Design and Access Statement

14 Westbourne Gardens Hove BN3 5PP

Proposed 1 Bed 1 Person New Dwelling on site of 3 existing garages (unused)

Pre-App

Proposed Site Plan
DRAWING

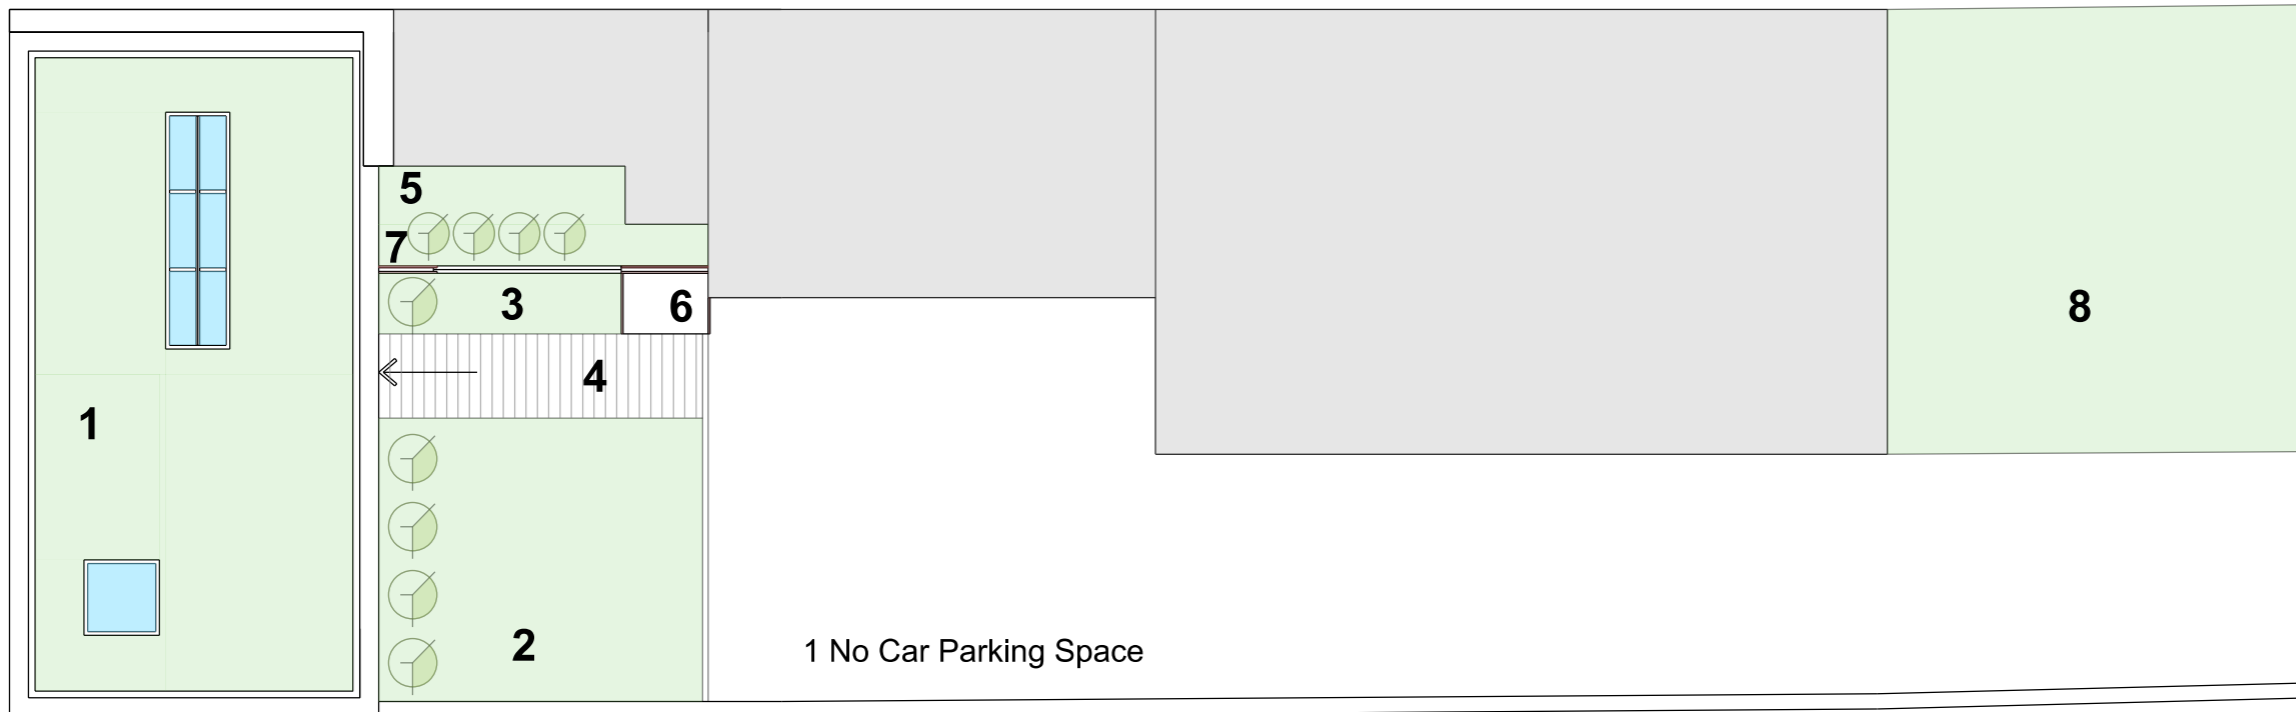
There would be no private outdoor amenity space for occupiers of the dwelling and no space to accommodate refuse/recycling storage or bicycles, contrary to policy. In addition, the only outdoor areas associated with no.14 would be significantly compromised.

A garden space is provided to the front of the proposed building. Refuse storage is also provided as will be secure bicycle storage. The existing space is not used as an amenity space by any of the flat owners of number 14.

Privacy/Garden Screen  
DRAWING

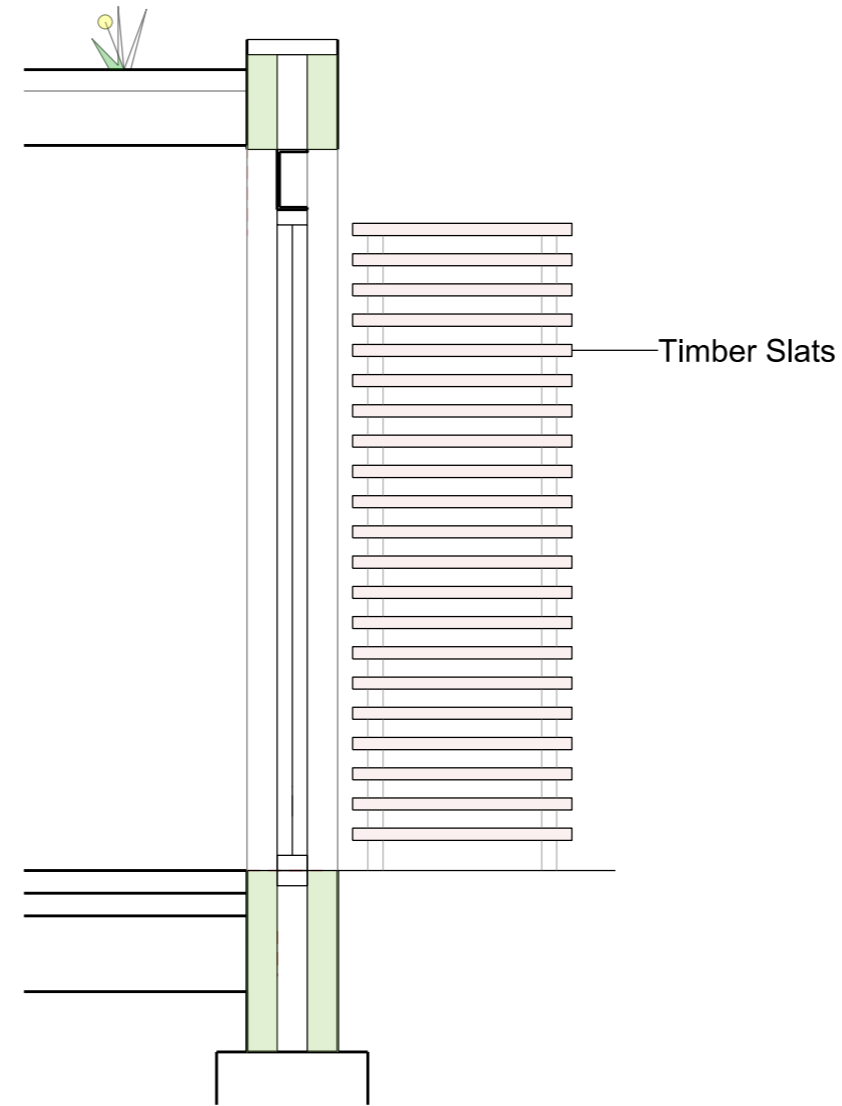
Potential overlooking from the rear elevation of 14 Westbourne Gardens. The drawings provided are not clear but any windows to the rear of Westbourne Gardens carry a significant risk of mutual overlooking with the proposed new flat, especially given the fully glazed frontage. The properties would be in very close proximity to each other which would result in a loss of amenity to both.

In addition, a slatted small privacy screen has been added. Further a perimeter screening garden has been provided to further distance the kitchen from the proposal. The kitchen presently looks out onto 3 disused garages. It will now have its own planted area and the garden associated with the proposal.

Proposed Roof Plan  
DRAWING

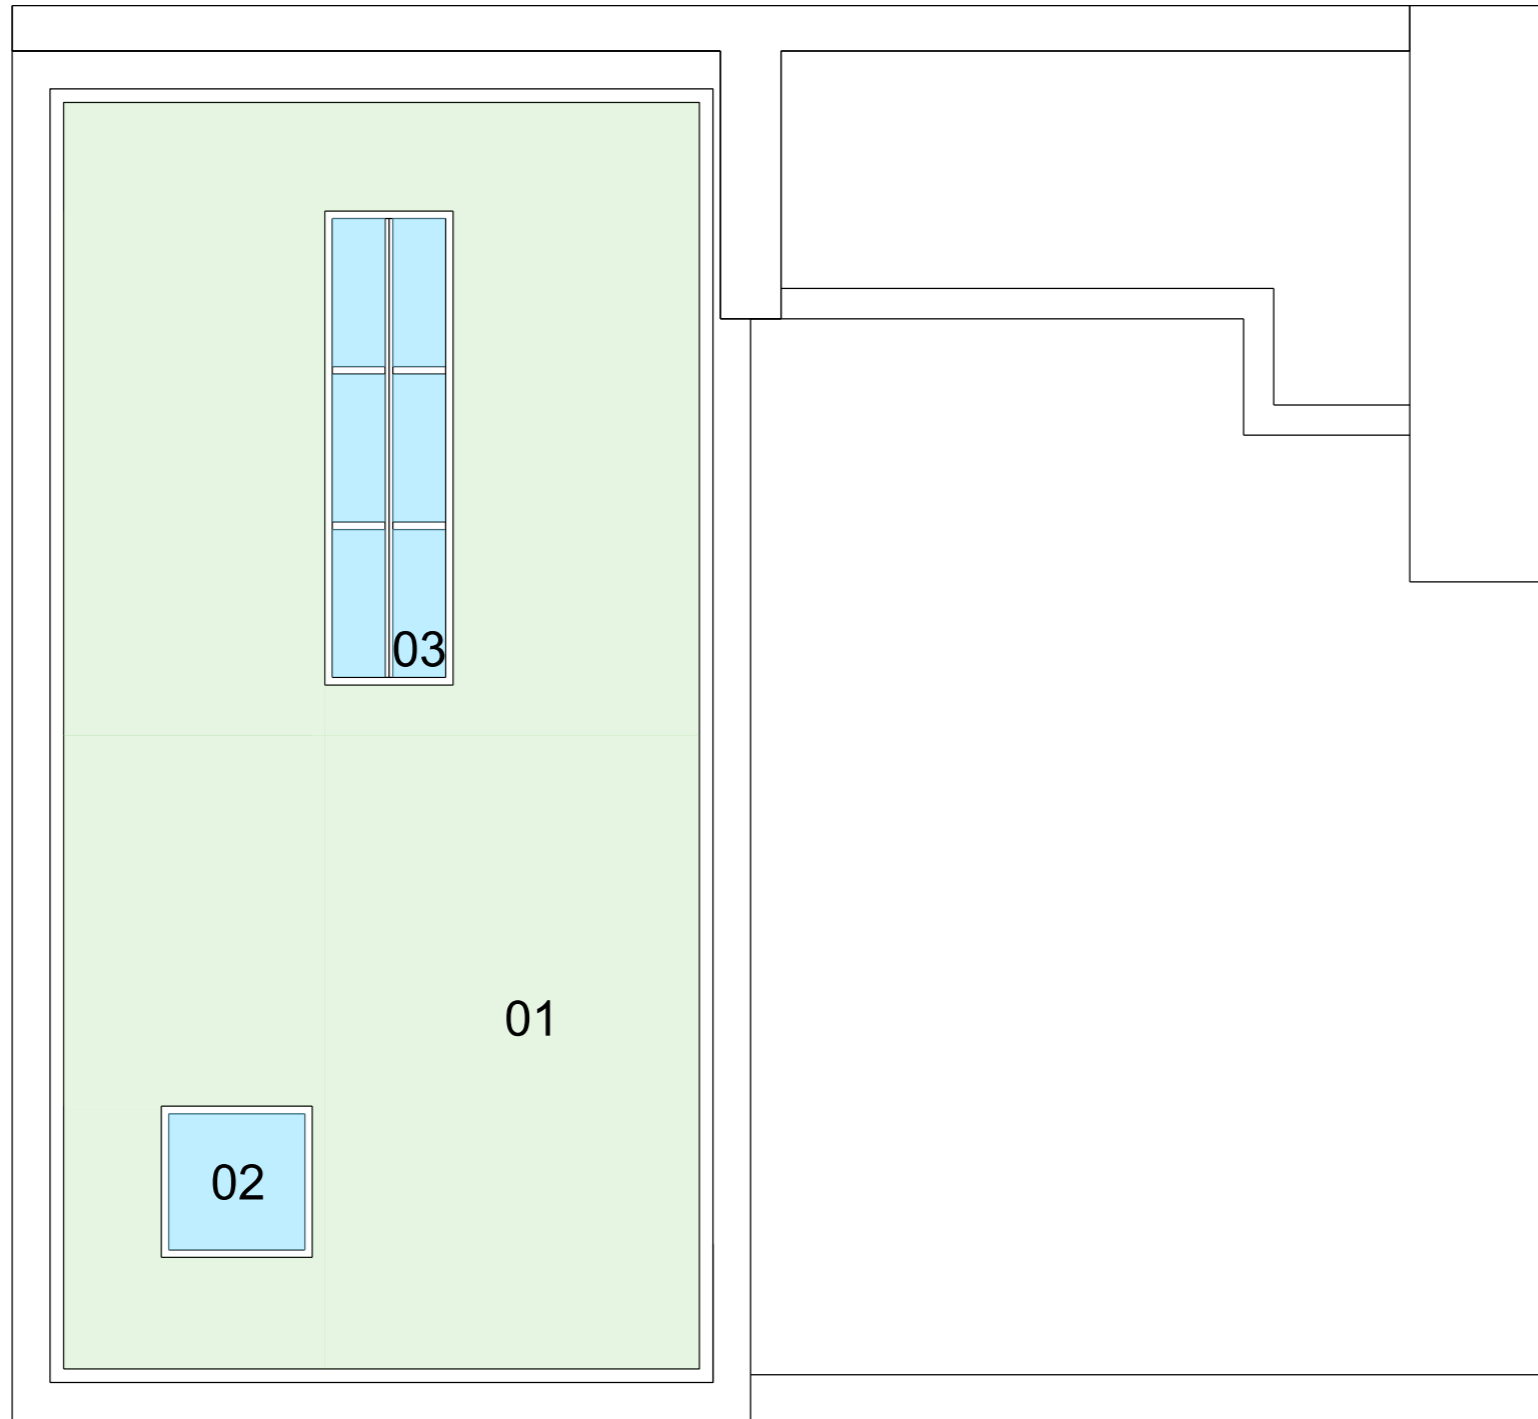
The proposed unit would be an east facing single aspect flat. This could result in limited light and ventilation, which is a concern.

A long lantern window is set in the green roof to capture west light and also light from south/north at its glazed ends. A rooflight is also set over the bathroom. The amount of glazing and rooflights will provide adequate natural light. Ventilation will comply with Building Regulations. Rooflights will be openable and background ventilation (trickle vent) will be built into window and rooflight frames.
